SUBMITTAL REVIEW COMMENTS

AE 0072-19 Mercer Island Transit Interchange

Submittal No./Ref./Title: 60% Submittal

AHJ: City of Mercer Island

**EAST LINK EXTENSION  
MERCER ISLAND TRANSIT INTERCHANGE**  
77TH AVE SE, 80TH AVE SE, & N MERCER WAY  
ROADWAY AND PAVING PLAN

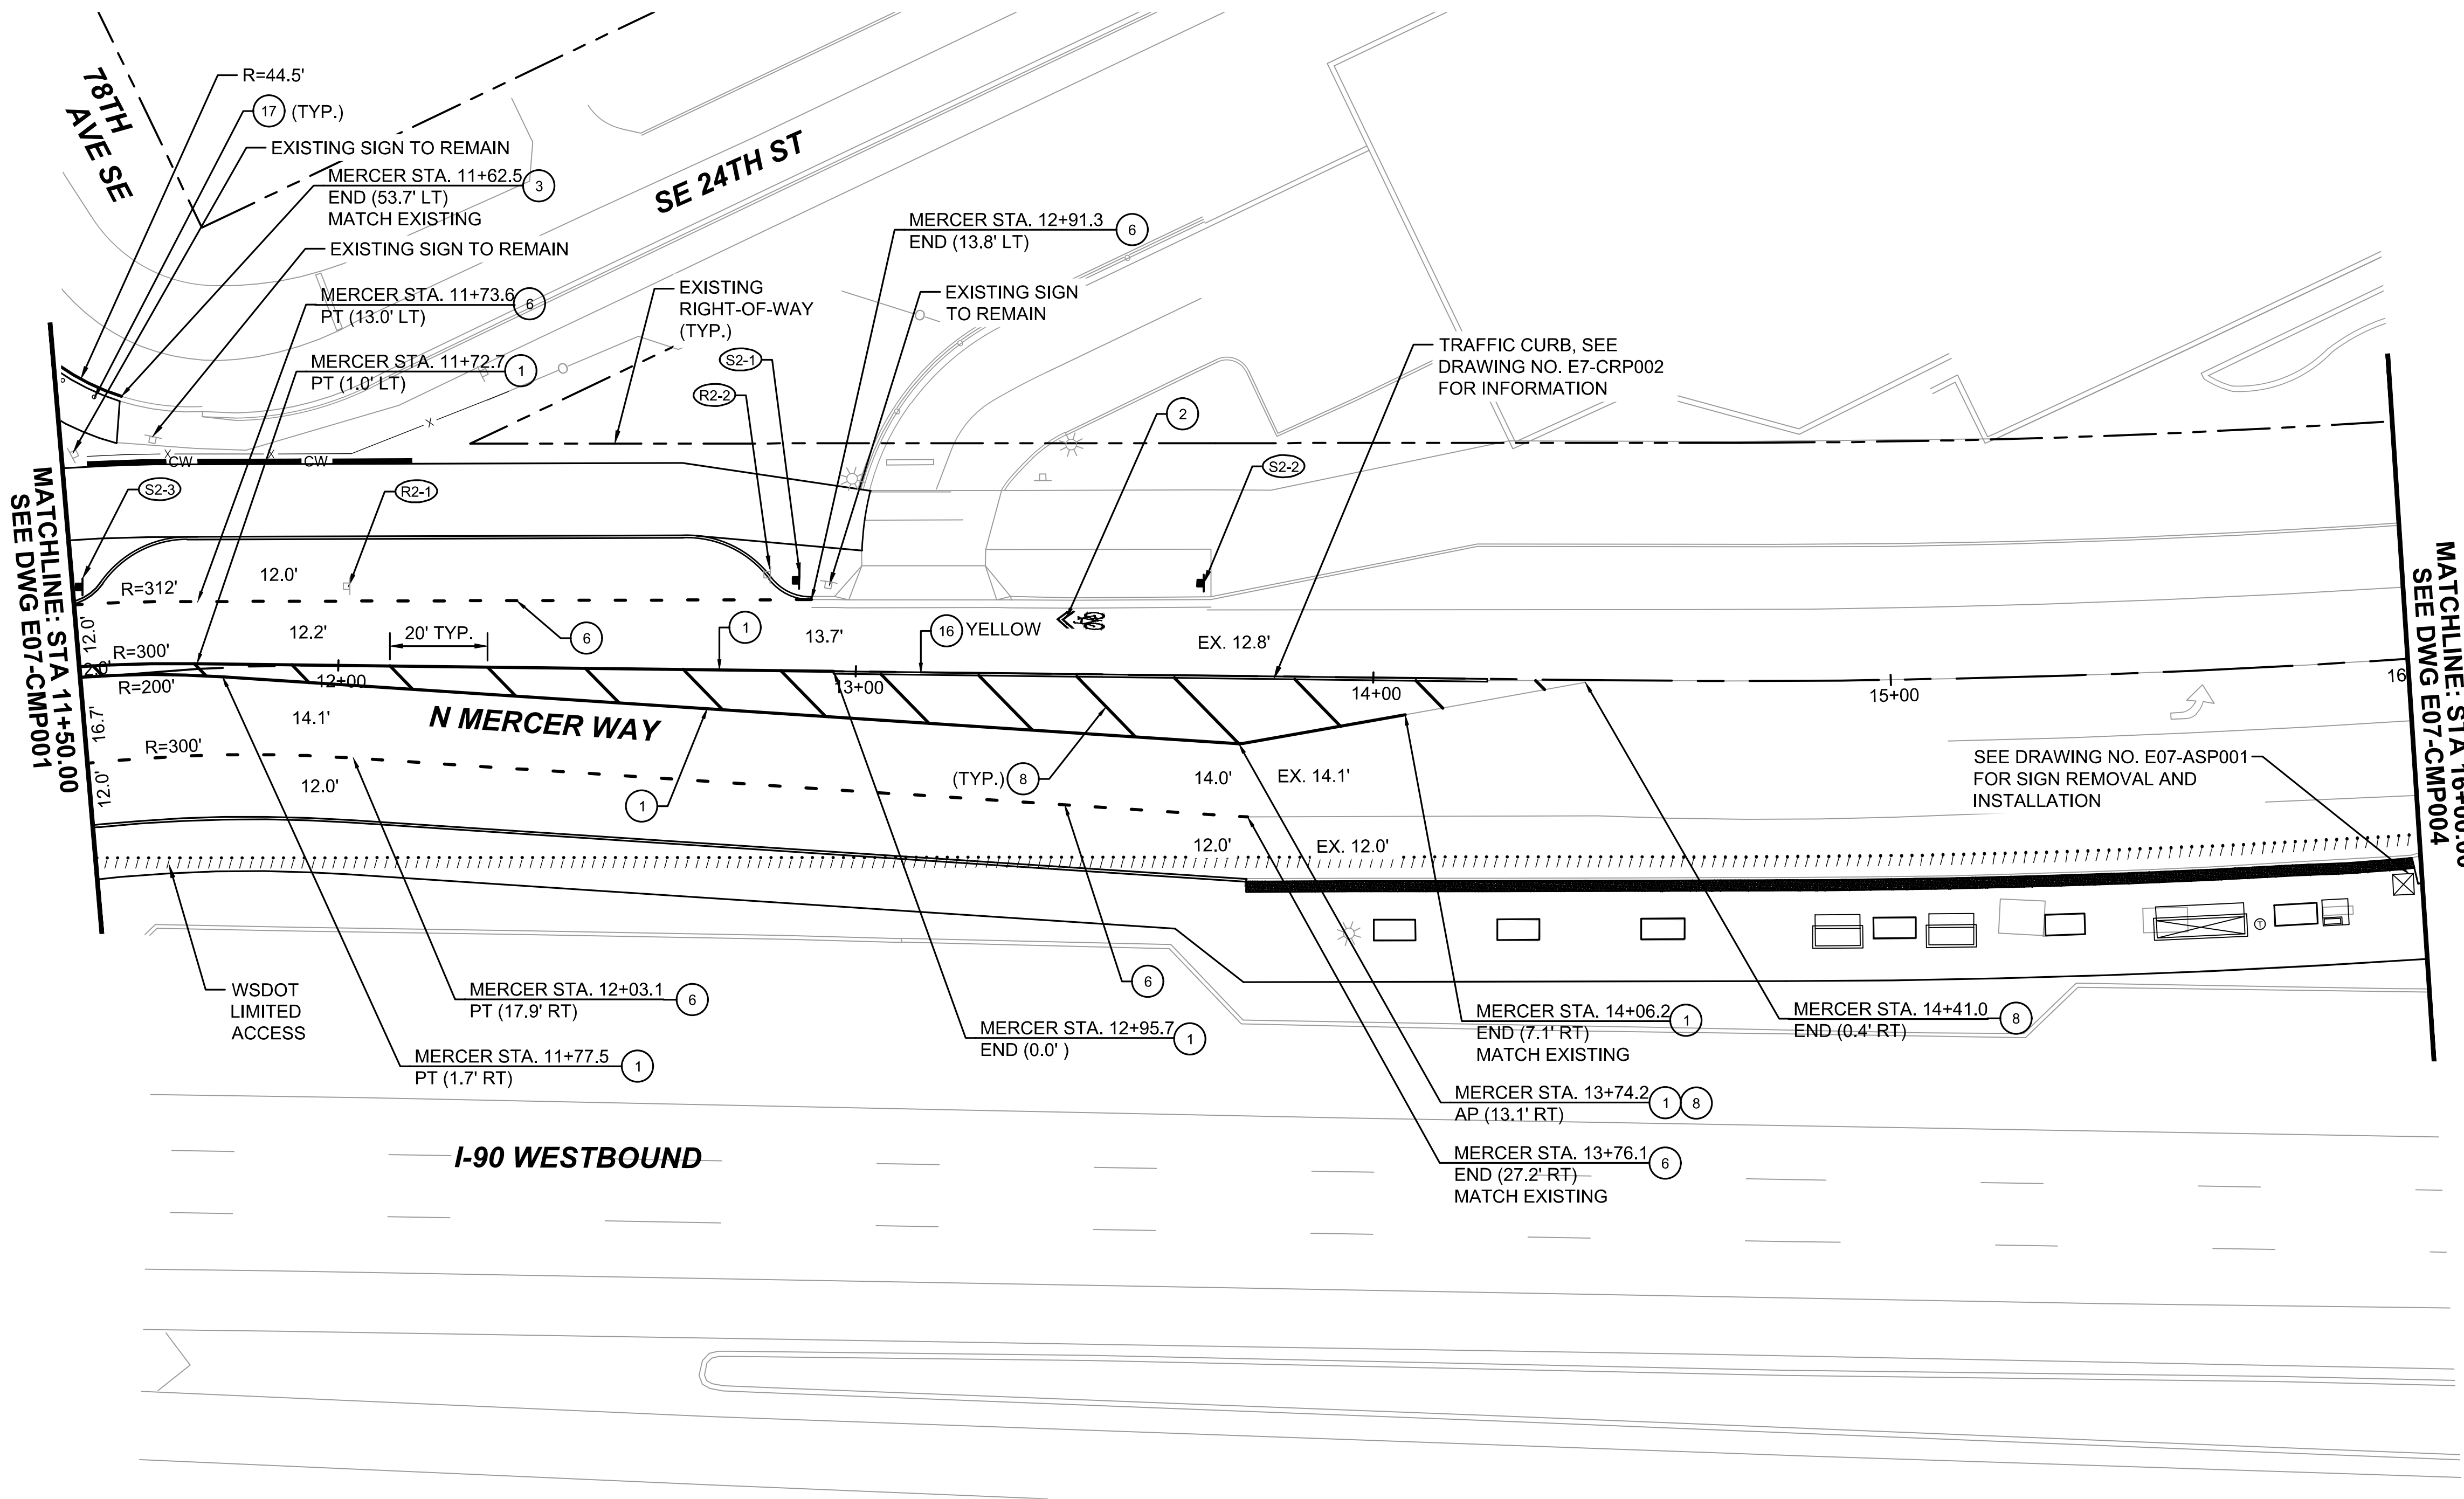
CPD35	60% Plan set	18/63, 41/63	EM	The settlement agreement (provision 4.2.a.) indicates that: "...all bus drop-off/pick-up and layover areas (other than those for local Mercer Island buses) will be located on the south side of North Mercer Way. (bold added)" Sheets CRP002, CMP002 reflects a new, approximately 140' pull out area on the north side of North Mercer Way. Please clarify the intended use of this pull out area.		S
CPD36	60% Plan set	19/63, 42/63	EM	The settlement agreement (provision 4.2.a.) indicates that: "There will be no drop-off/pick-up or layover area on 80 th Avenue SE." Sheet CRP003 reflects a new, approximately 90' pull out area on the west side of 80 th Avenue SE.	No transit use (kiss ride/uber drop off, pickup, etc.) intended on 80 th . The drive opening is for Emergency/Service vehicles.	CD
